**WELWYN HATFIELD BOROUGH COUNCIL  
EXECUTIVE DIRECTOR - PLANNING, PUBLIC PROTECTION AND GOVERNANCE**

**DELEGATED APPLICATION**

**Application No:** 6/2021/0915/LAWP  
**Location:** 25 Daisy Drive Hatfield AL10 9FR  
**Proposal:** Certificate of lawfulness for the erection of a loft conversion consisting of a rear dormer and front velux windows  
**Officer:** Ms Lois-May Chapman

**Recommendation:** Refused

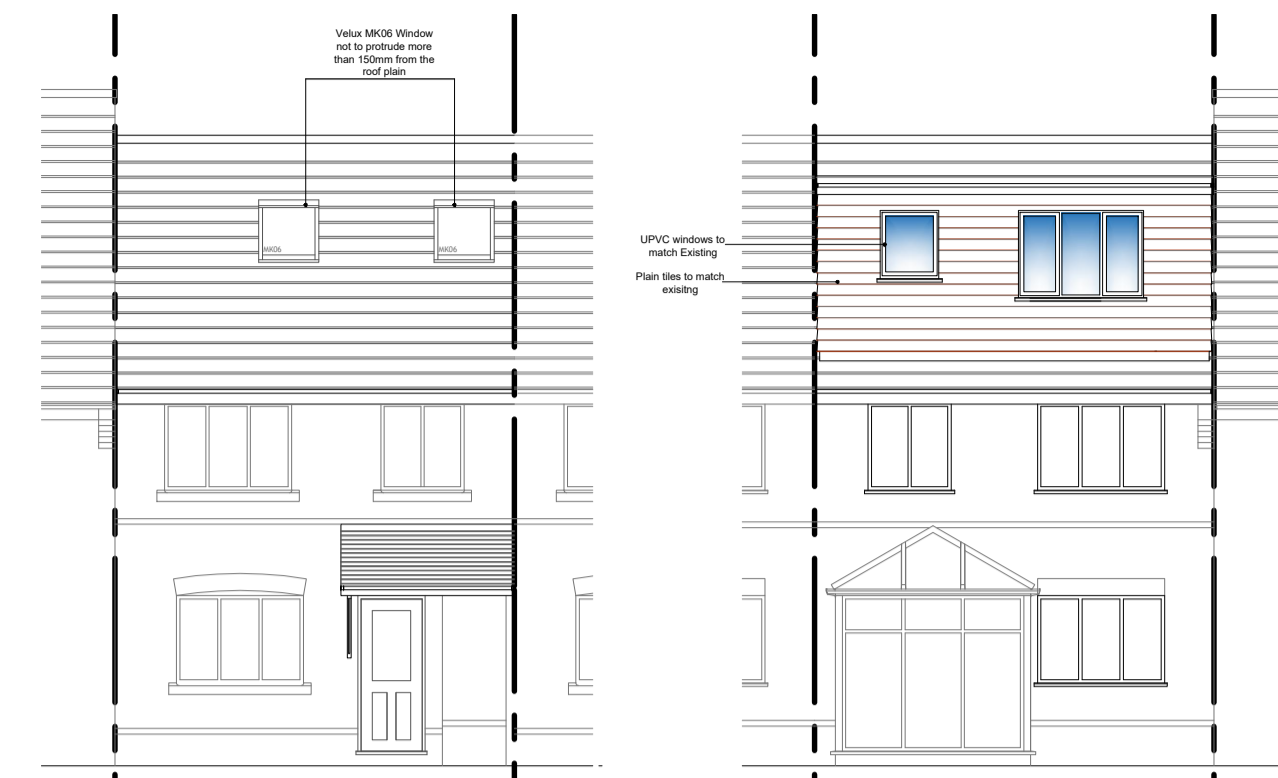
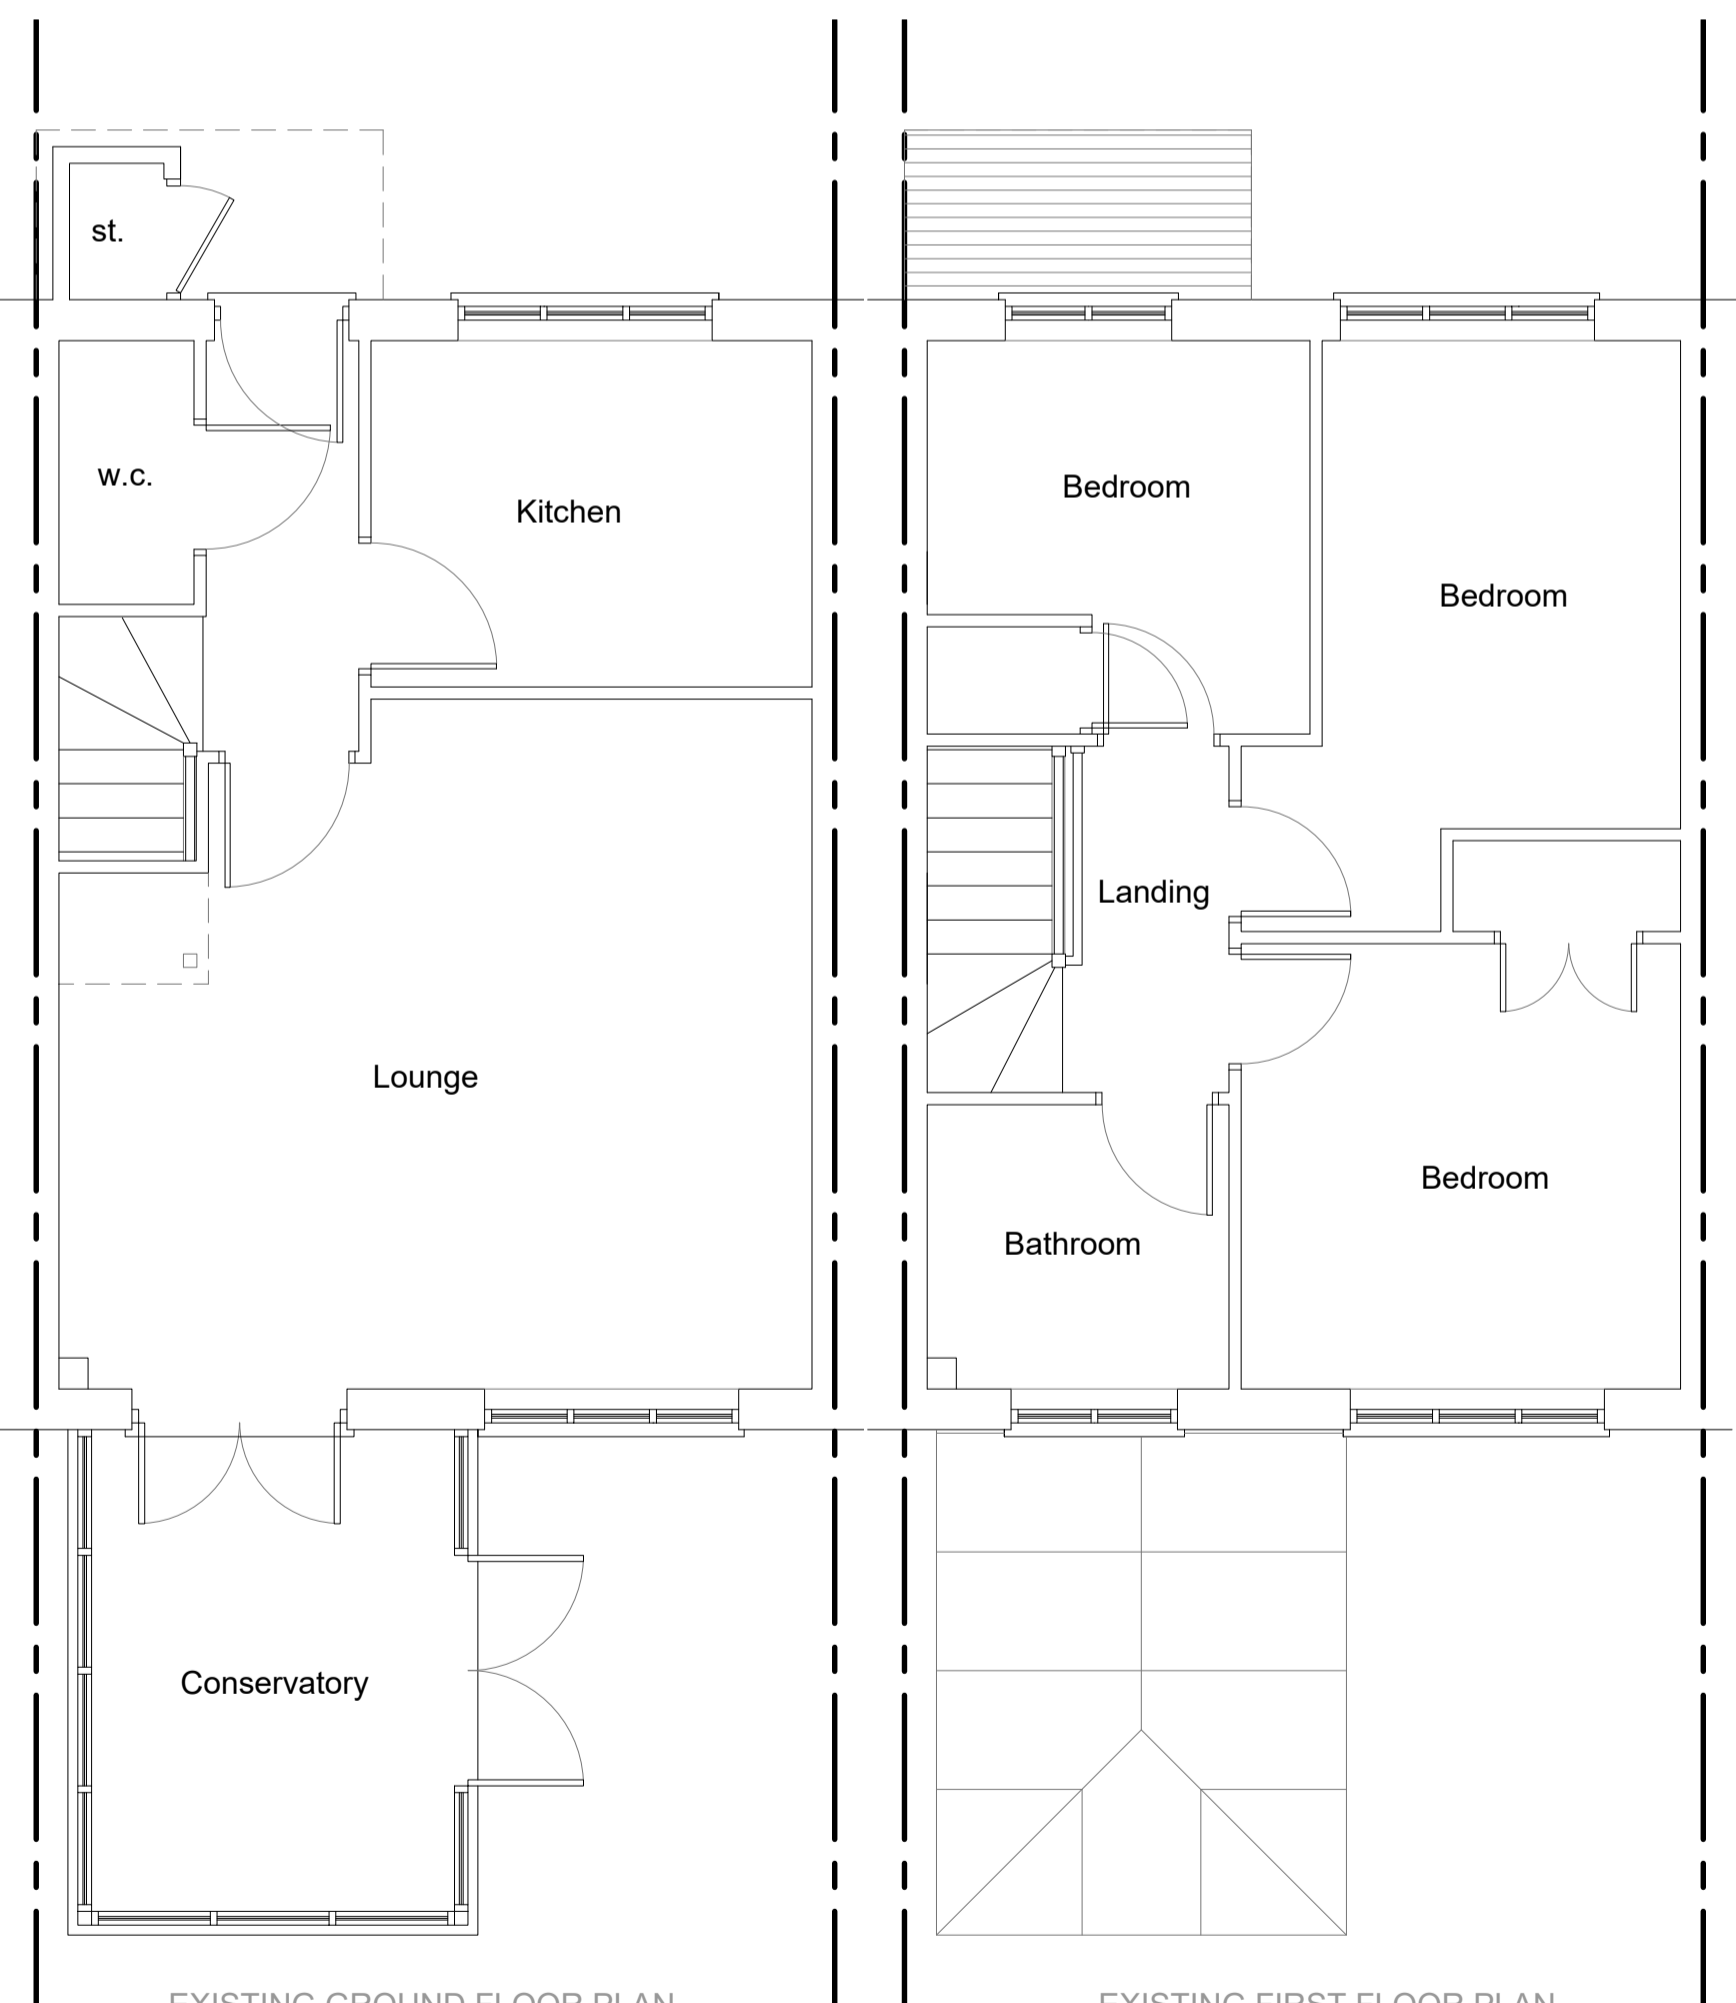
(d) would the cubic content of the resulting roof space exceed the cubic content of the original roof space by more than:- (i) 40 cubic metres in the case of a terrace house, or (ii) 50 cubic metres in any other case	N	N
<i>Dormer -</i>		
$\frac{1}{2} \times 2.5 (H) \times 3.3 (D) \times 5.2 (L) = 21.45 m^3$

1. The proposed works are not permitted development by virtue of Schedule 2, Part 1, Class B of the Town and Country Planning (General Permitted Development) (England) Order 2015 as amended by virtue of permitted development rights being removed by condition 16 of planning application S6/2001/0577/FP granted on the 24 July 2003.
